### PLANNING APPLICATION CONSULTATION RESPONSE

<b>Application Number:</b>	3/2021/1134
<b>Location:</b>	Land East of Chipping Lane, Longridge
<b>Proposal:</b>	Development of Phases 2 and 3 for the erection of 198 dwellings, including affordable housing and housing for older people, with associated landscaping, SUDS, LEAP, and areas of open space.

The Lead Local Flood Authority **objects** to the development proposal on the basis of:

## **Inadequate Drainage Strategy**

Figure 6: Preliminary Proposed Drainage Plan extract (Betts Hydro, 2021)

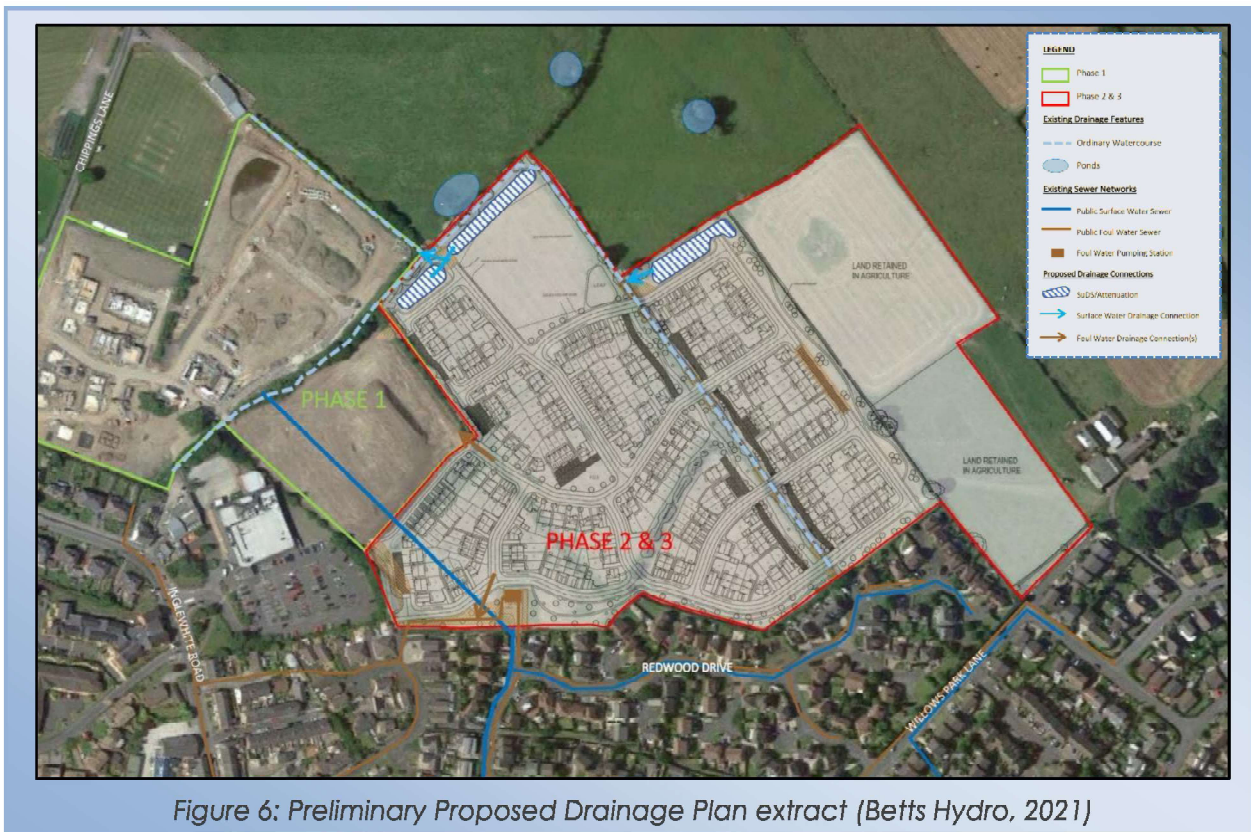
- The flood risk assessment and drainage strategy provided are scanned copies and therefore some the design details on the indicative drainage layout are illegible, meaning that a full assessment of the information can not be completed.

You can overcome our objection by submitting information which demonstrates how surface water will be managed on site, satisfying the principles of Paragraph 169 of the NPPF and the PPG.
